Ribble Valley Borough Council
Housing & Development Control

Application no: **3/2023/0156**

Address: **Dog and Partridge Hesketh Lane Chipping PR3 2TH**

Proposal: **Conversion and extension of former Dog & Partridge to form one dwelling and six residential apartments and the erection of four buildings for holiday accommodation use and detached garage.**

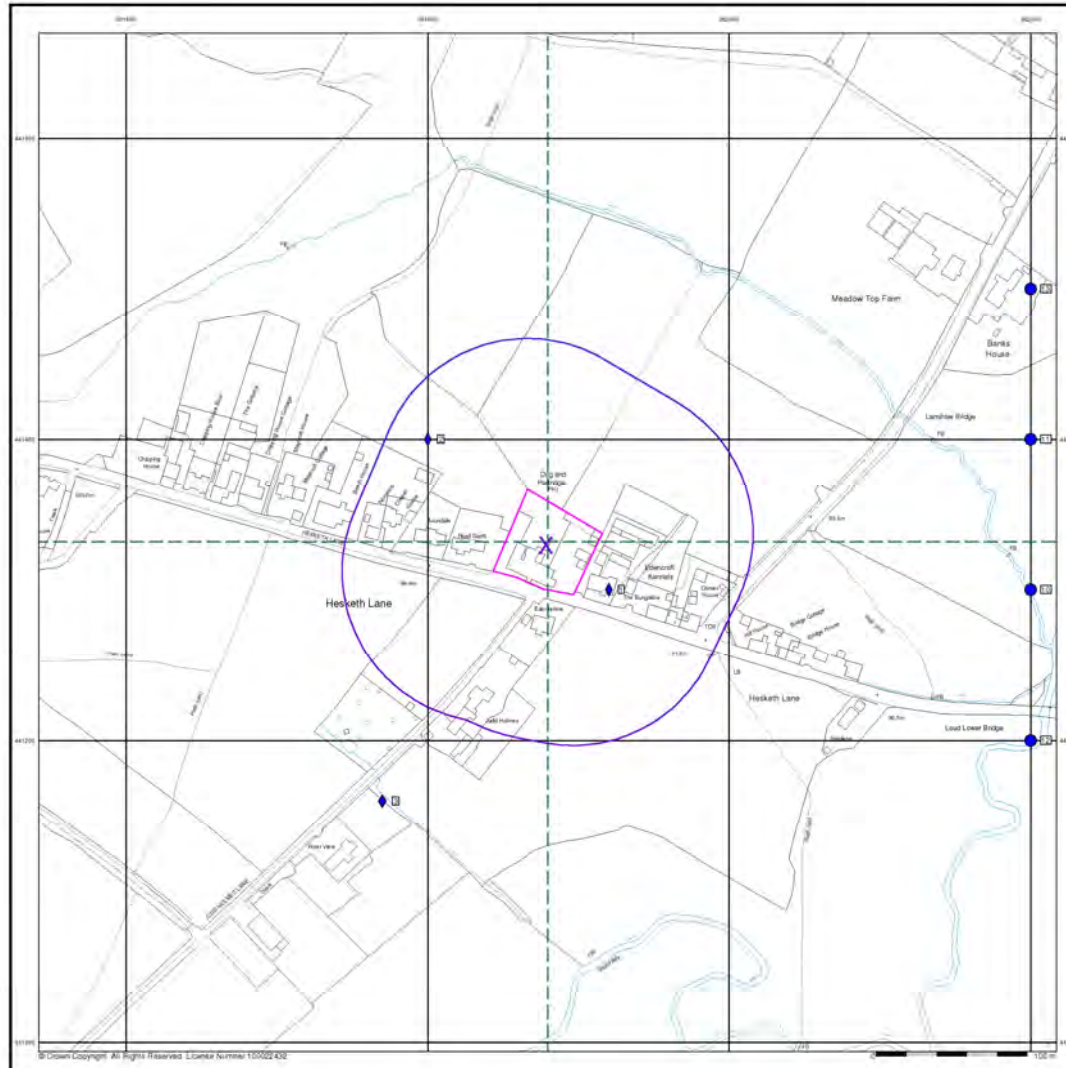
The LHA have reviewed Black Barn drawing number P05 Rev B titled "Proposed Site Plan" and are aware that the existing site access will be improved and will serve the 5 apartments and 4 holiday lets. While an existing secondary access located adjacent to the dwelling called "Roall Garth," will serve the proposed dwelling.

Firstly, the LHA have reviewed the site access which will serve the proposed 6 apartments and 4 holiday lets and are aware that the access will form a bellmouth formation with improved kerb radii to make turning movements into and out of the site easier. The access will also be approximately 5.8m, where it will then reduce to 5m wide when the access reaches the access gate which is also setback 5m from the adopted highway.

While the LHA would prefer the access to be 6m wide, the LHA will accept the shortfall with this being minimal and the internal access track widening to 6m once past the gated access. Therefore, the LHA have no further comments to make regarding the access width.

However, the LHA are aware, as shown on Black Barn drawing number P05 Rev B, that the site can provide visibility splays of 2.4m x 70m in both directions. These visibility splays do not comply with the LHAs guidance, with the LHA requiring the site to provide visibility splays of 2.4m x 214m in both directions given the speed of the road.

Despite this, the LHA will accept the shortfall in visibility at the site access. This is because the access previously generated vehicle movements in its own right when it served the Public House and restaurant. Therefore, given that the previous use likely generated more trips than the proposed use, a similar access being approved under application reference 3/2018/0786 and there being no Personal Injury Collisions recorded within 500m of the site access in the last 5 years, the LHA will accept the shortfall in visibility.

The LHA have further reviewed the access which will serve the proposed 3 bed dwelling and are aware that the access width complies with the LHAs guidance. The LHA will condition that the access provides visibility splays of 2m x 70m in both directions, alike the access serving the apartments and holiday lets.

The LHA have reviewed Black Barn drawing number P05 Rev B titled "Proposed Site Plan" and are aware that the parking arrangements for the proposed 3 bed dwelling and 4 holiday lets comply with the LHAs parking guidance as defined in the Joint Lancashire Structure Plan.

However, the LHA are aware that the site will provide 8 car parking spaces for the 4x 2 bed and 2x 1 bed apartments. While the parking arrangements do not comply with the LHAs parking guidance, with the LHA requiring 10 spaces to be provided, the LHA will accept the shortfall with it being minimal.

2.No part of the development hereby permitted shall be occupied until such time as the access arrangements shown on Black Barn drawing number P05 Rev B have been implemented in full.

3. No part of the development hereby permitted shall be occupied until such time as vehicular visibility splays of 2.4 metres by 70 metres have been provided at the site access serving the proposed 6 apartments and 4 holiday lets and vehicular visibility splays of 2 metres by 70 metres have been provided at the site access serving the proposed dwelling. These shall thereafter be permanently maintained with nothing within those splays higher than 1 metres above the level of the adjacent footway/verge/highway.

7. The development hereby permitted shall not be occupied until such time as the parking and turning facilities have been implemented in accordance with Black Barn drawing number P05 Rev B. Thereafter the onsite parking provision shall be so maintained in perpetuity.
